Objection to Planning Application: [2026/62/90484/E]

Address of Proposal: [143 Church Lane, Gomersal, BD19 4QN]

Proposed Development: Change of use from C3 (Residential) to C2 (Residential Institution up to 4 individuals aged 7-18) and extension above existing garage.

Alterations and Extensions to  
143 Church Lane Gomersal, Cleckheaton,  
BD19 4QN.

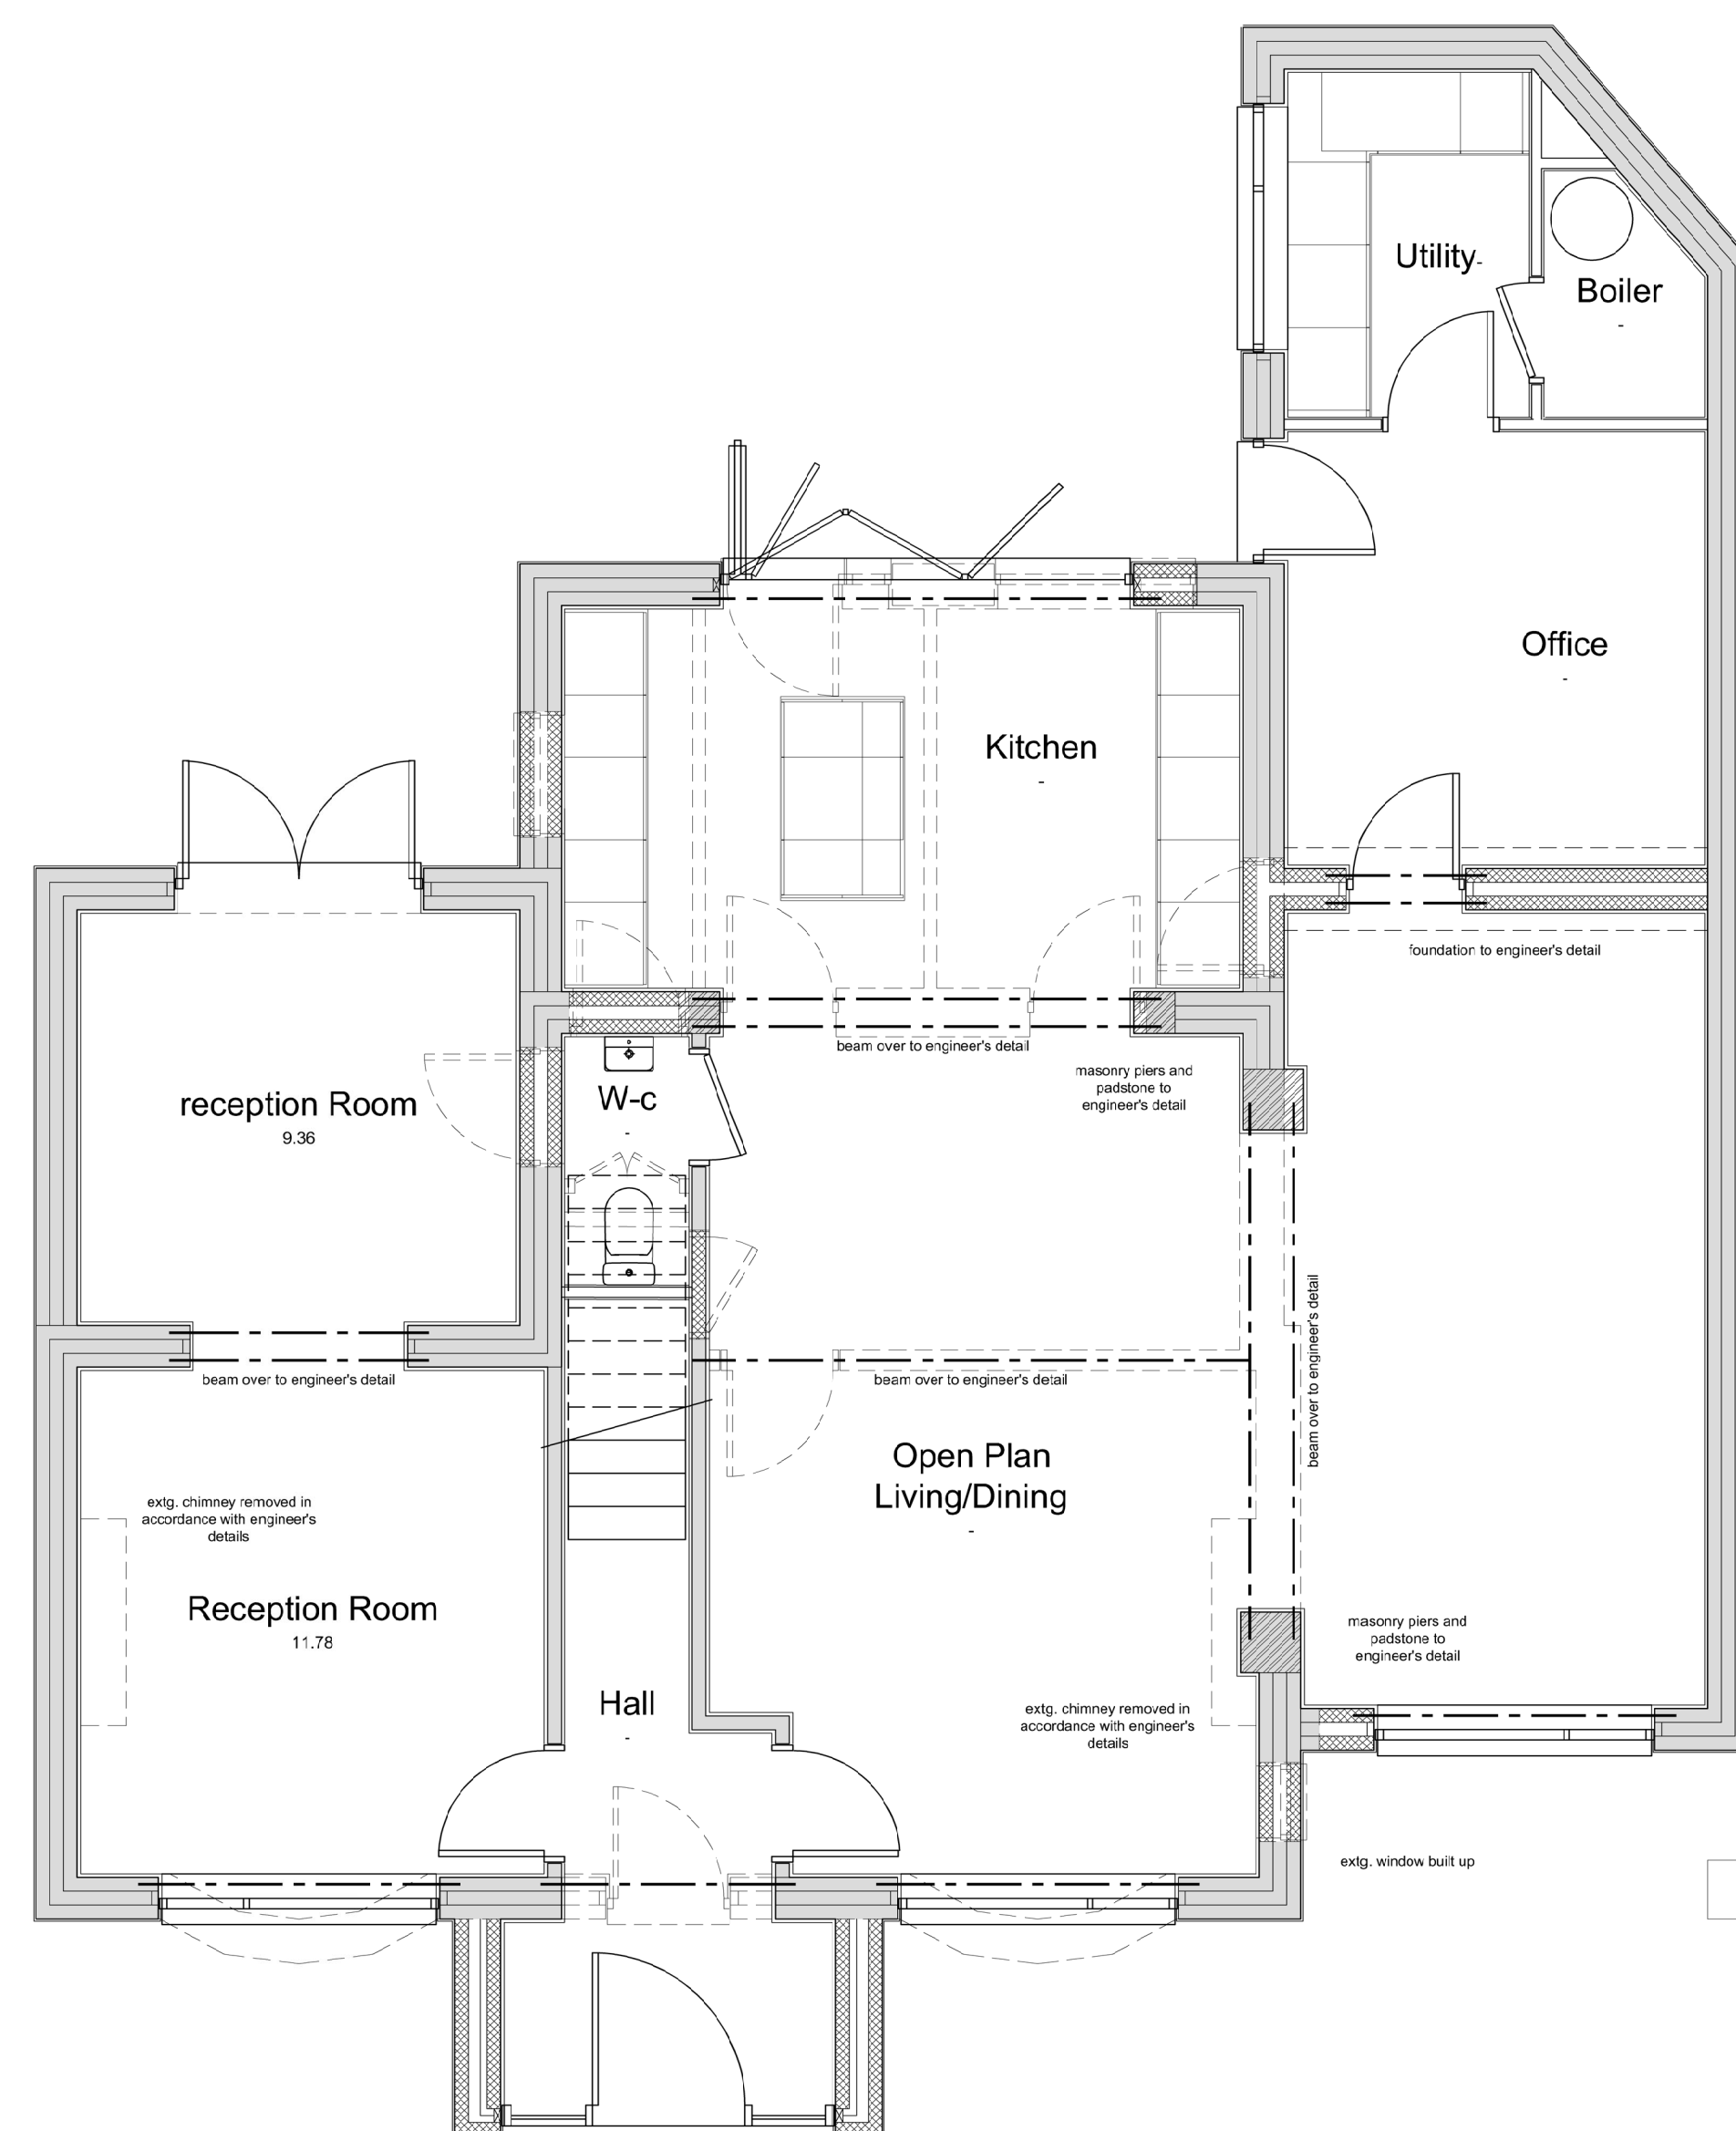
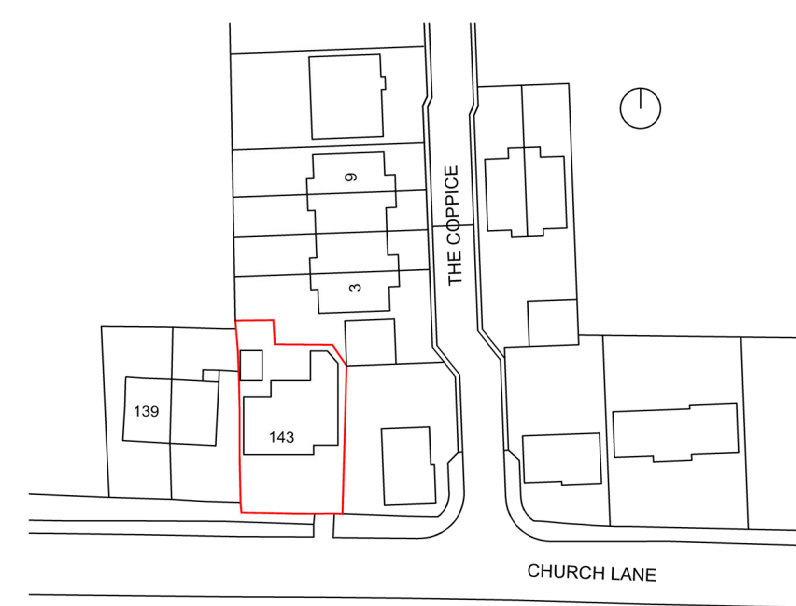
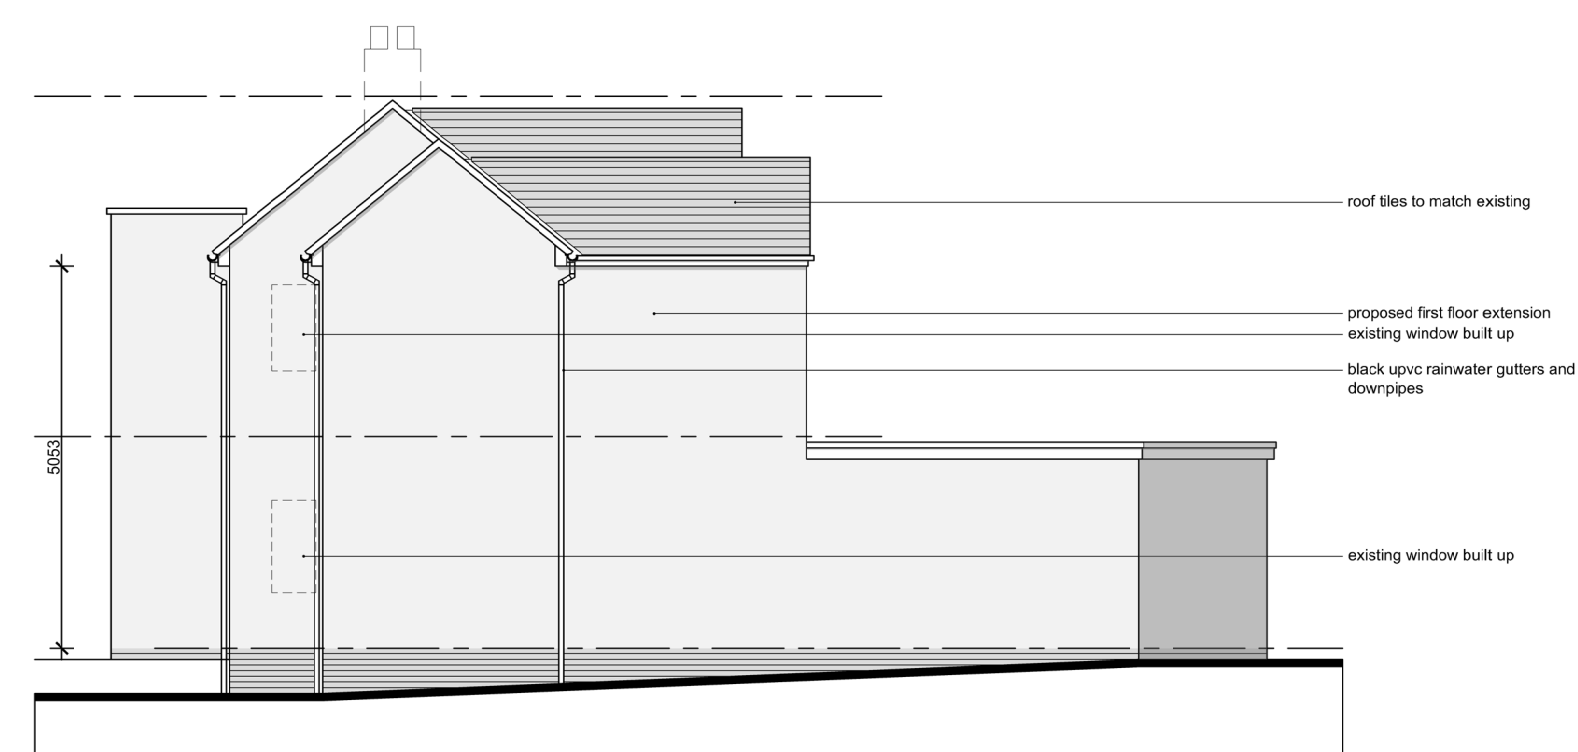
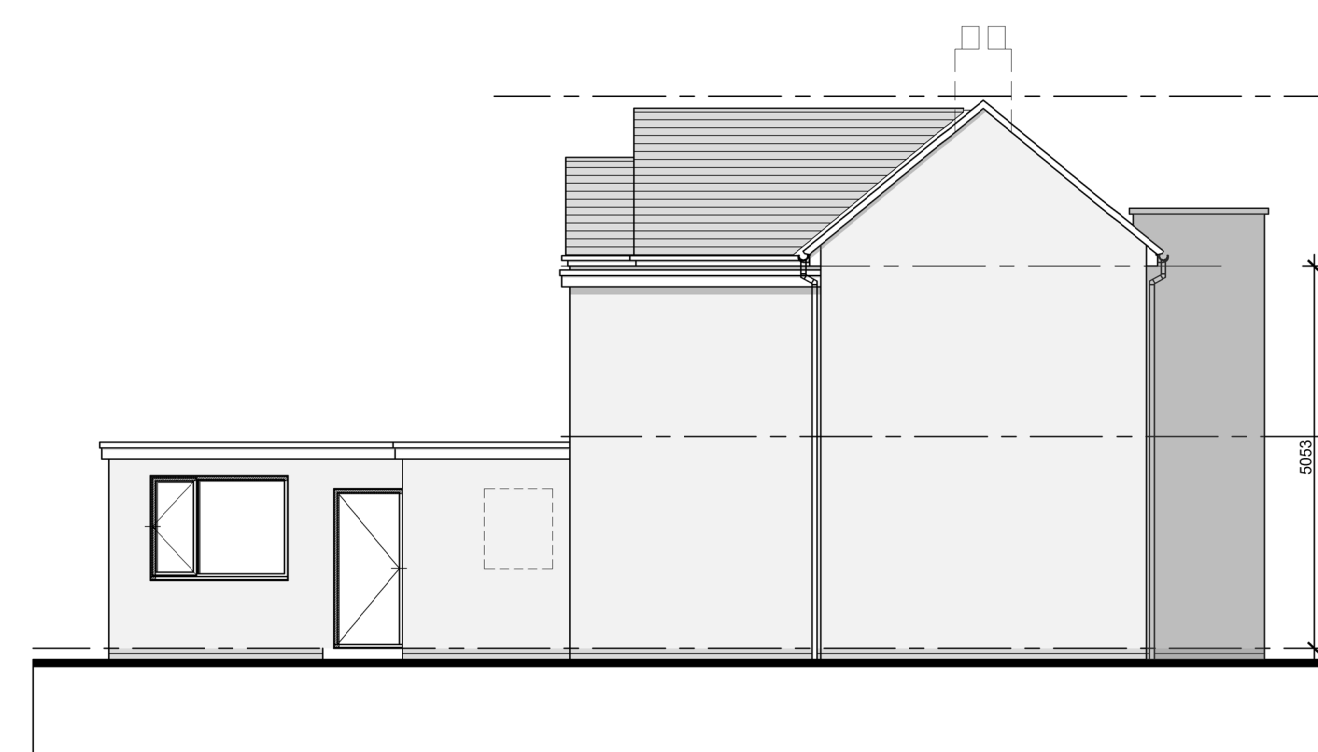
- Ideally the property should provide safe, well-maintained outdoor spaces to support children's physical/mental health and wellbeing offering areas for active play. From looking at the plans submitted, outdoor space is extremely limited.

- If the planning for building over the existing garage was allowed it would present significant privacy issues for the nearby existing houses and indeed any children placed at 143 Church Lane.

- Two of the adjacent gardens are much lower than 143 Church Lane meaning the existing garage is already a significant height. Building a second-floor extension will seriously impact on natural daylight and privacy. Plans show an overdevelopment of the site hence little outdoor space. A site visit would illustrate this much better rather than just looking at plans.
